2023/0783

Erection of single storey rear extension to rear of the single storey cottage, excavation works to rear to create new levelled out rear garden with paving surface and replacement retaining walls and fences around the perimeter.

Chimney Cottage, The Avenue, Wortley, Sheffield, S35 7DB

Site Levels
Scale: 1 : 200

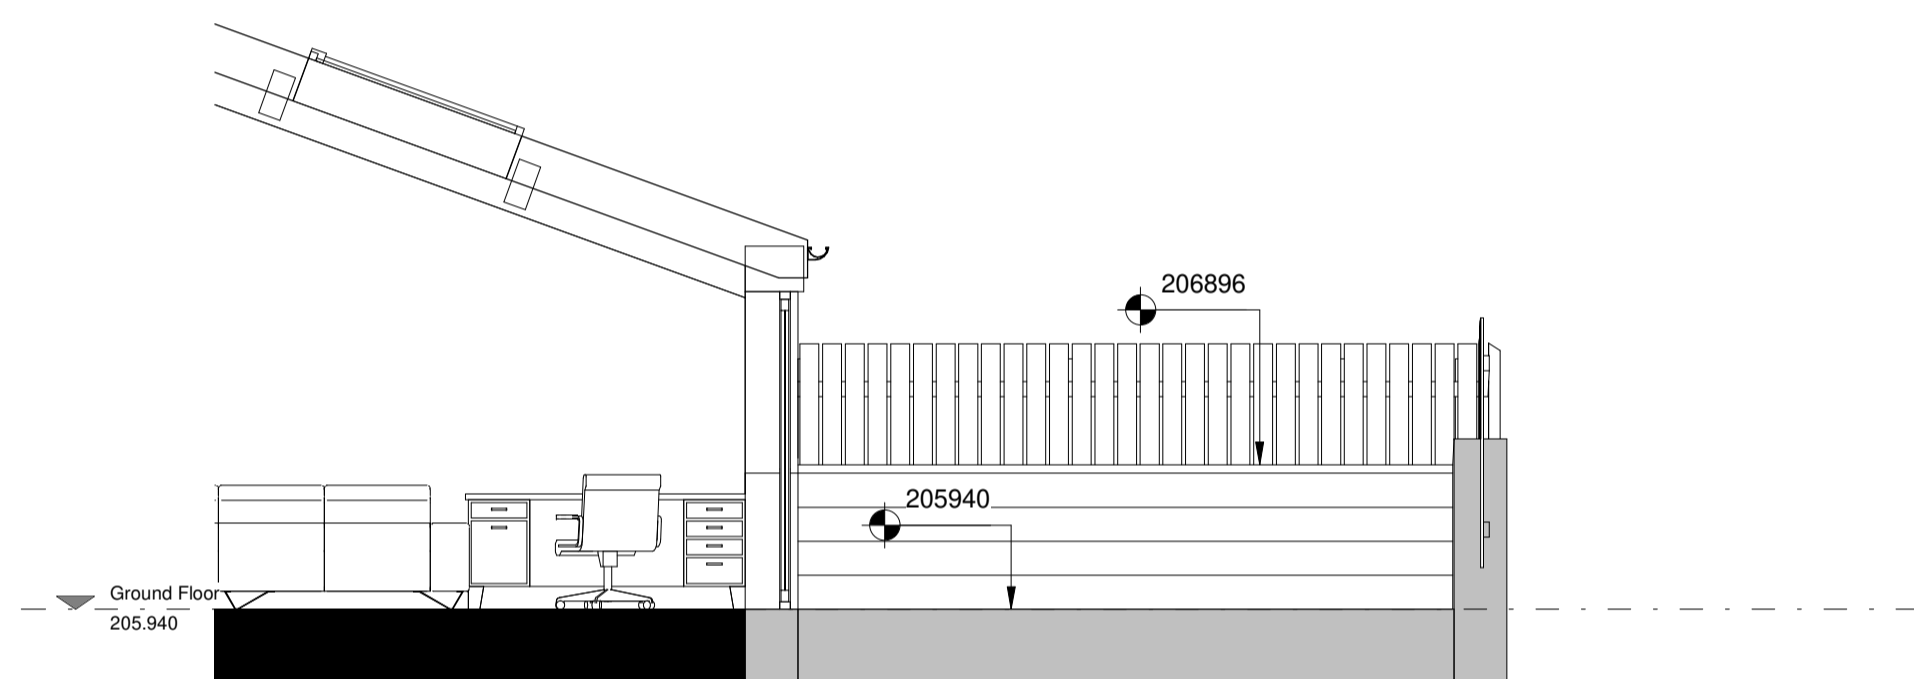
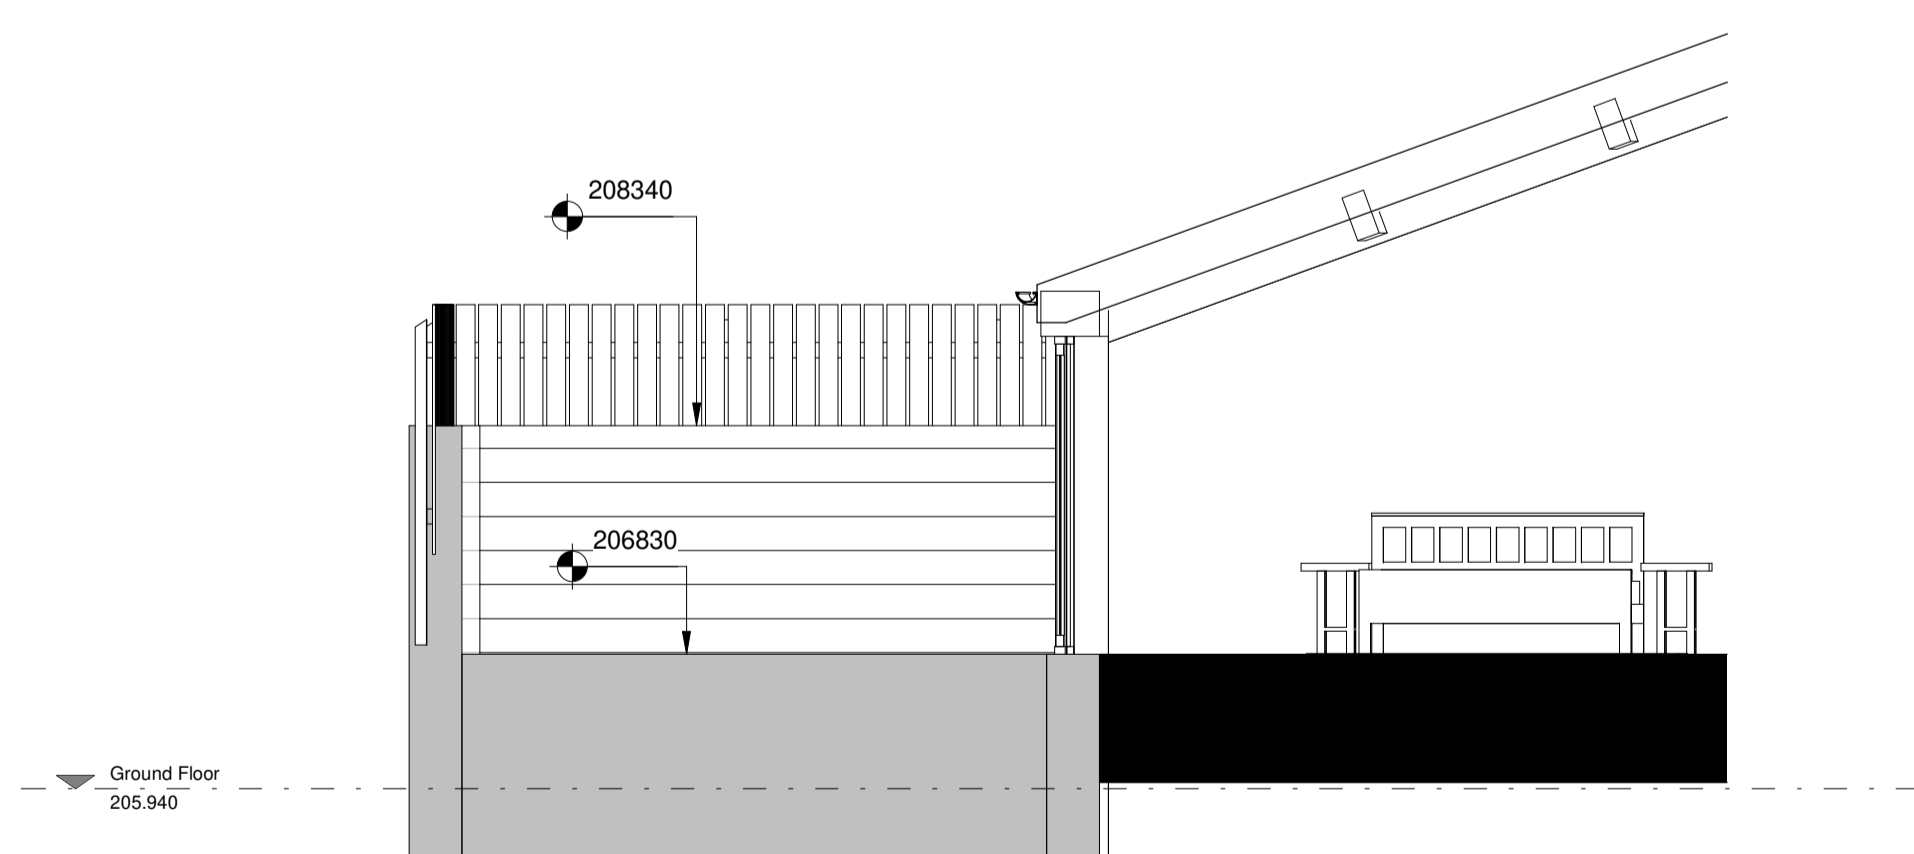
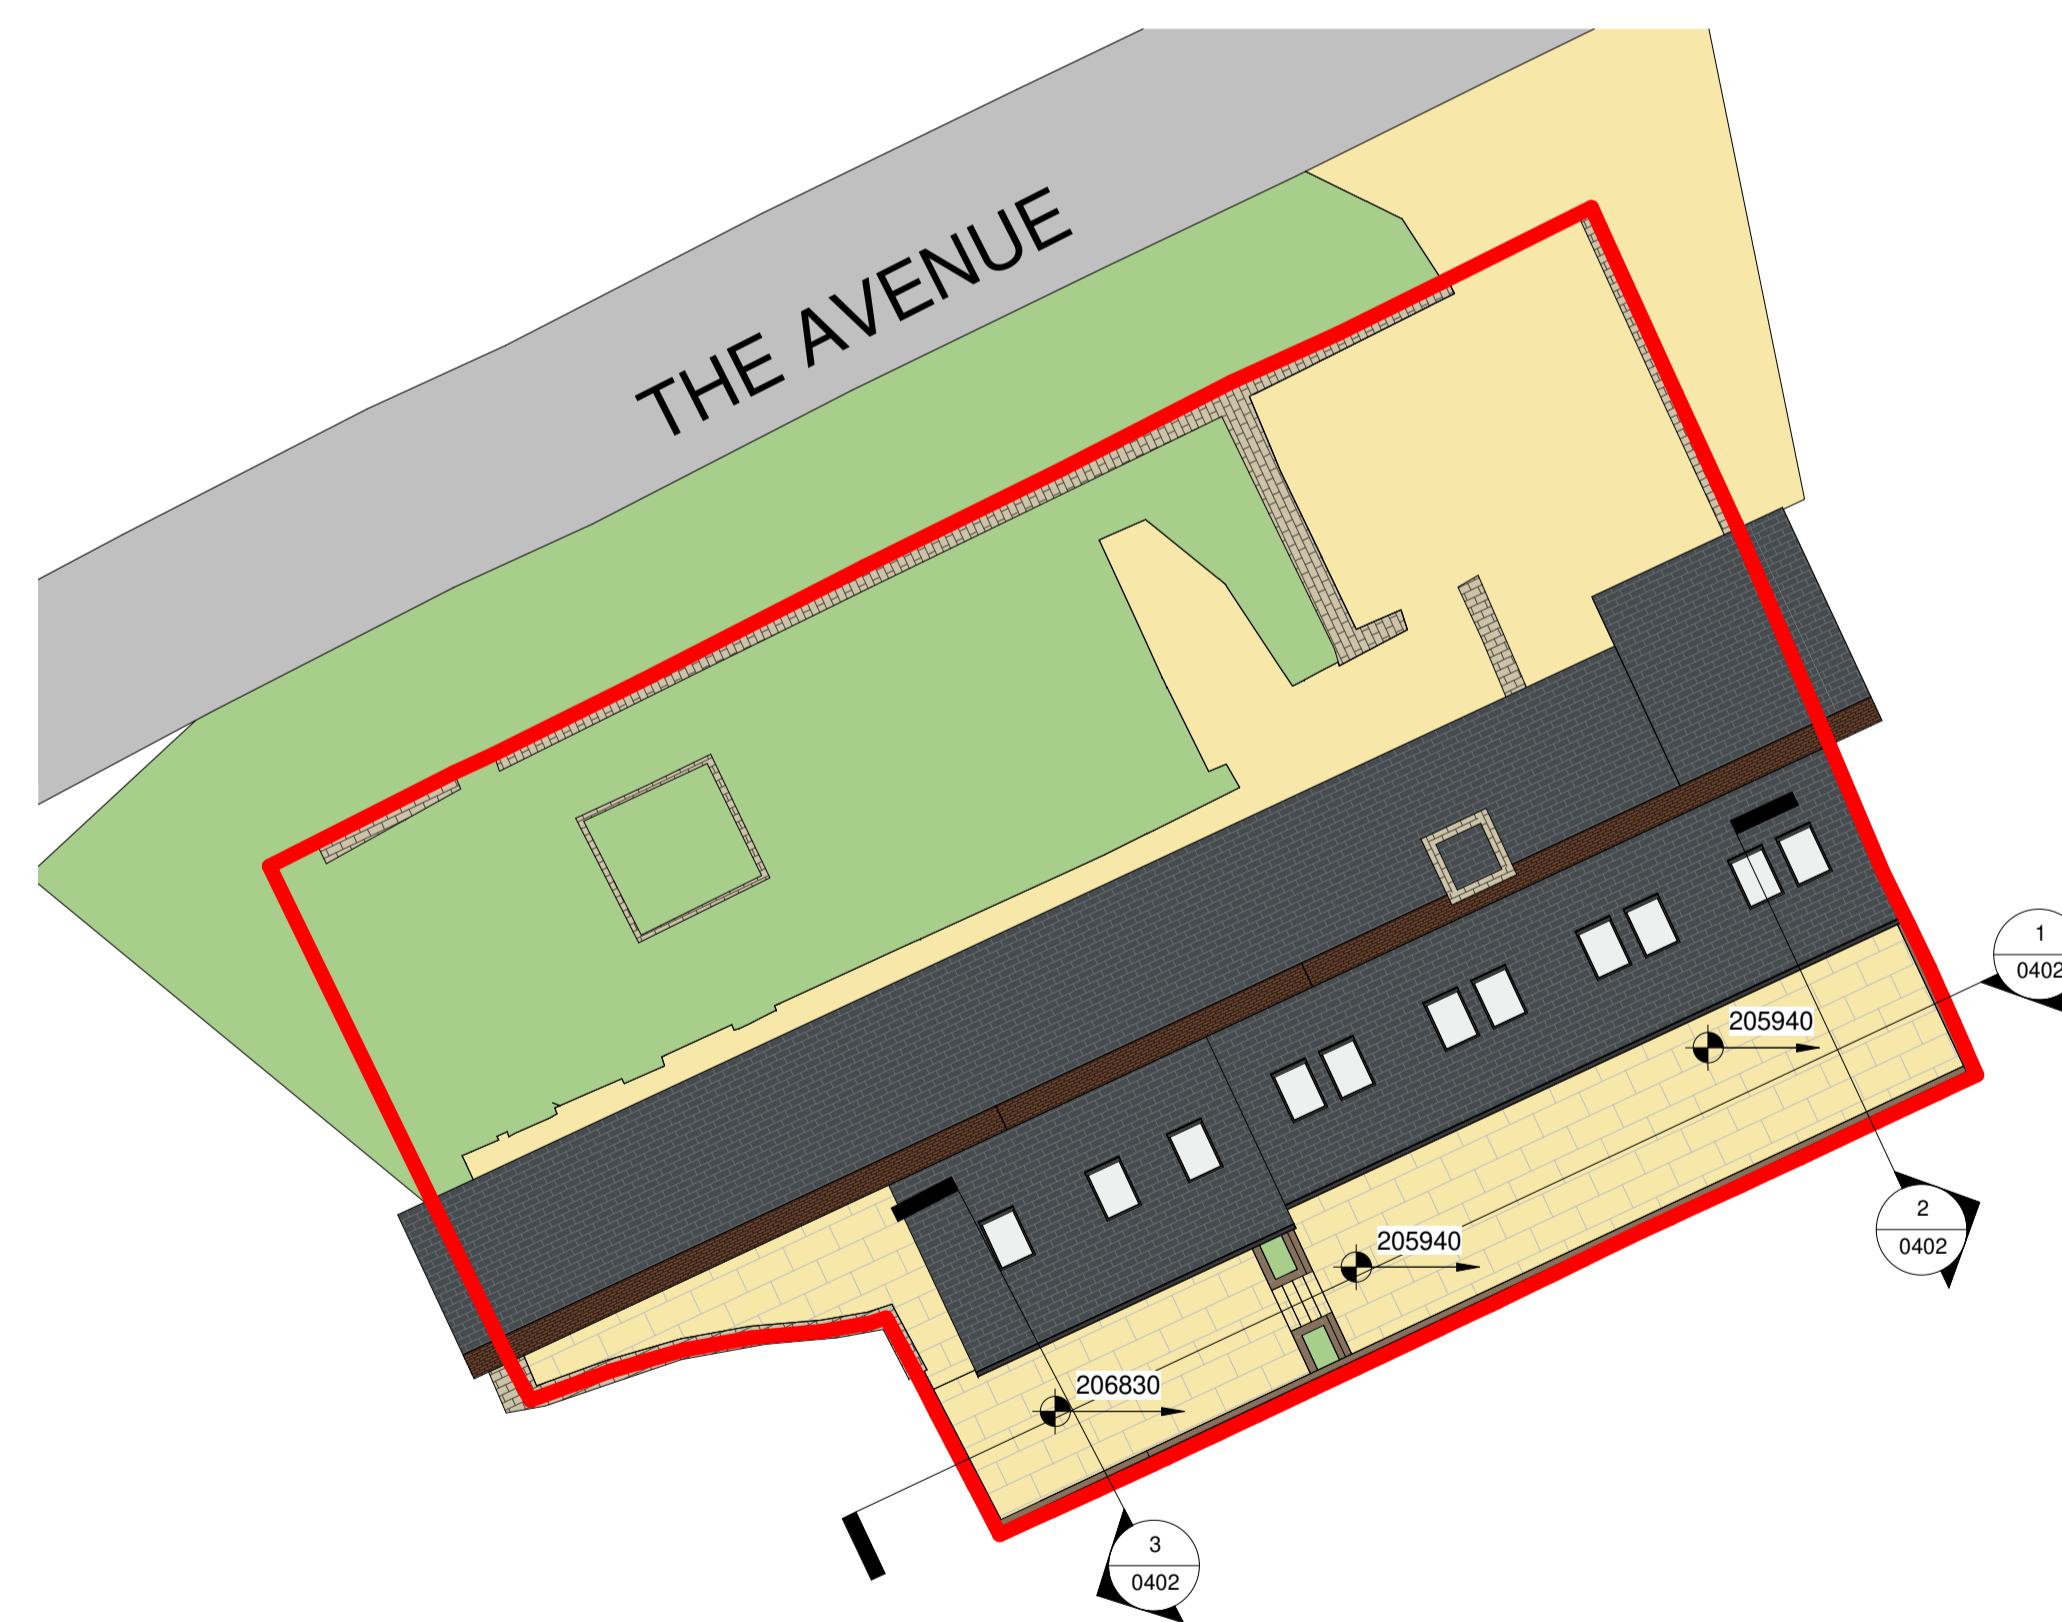
The plans refer to the inclusion of a retaining wall, due to the level changes within the site and with the walled garden to the rear, a retaining structure is required. The inclusion of the retaining wall is considered acceptable and is not considered to impact on the setting of the listed building. The original plans included a solid timber fence along the rear boundary; it was considered that this was too stark and domesticated for the setting and amendments were subsequently proposed. The amendments included a post and rail fence with hedge to provide privacy of the property from the walled garden, details of which are to be agreed via condition.

Upon commencement of development a plan outlining details of boundary treatments to be erected, including positioning, shall be submitted to and approved in writing by the Local Planning Authority. The boundary treatment shall be completed before the dwelling is occupied. Development shall be carried out in accordance with the approved details and shall thereafter be retained.
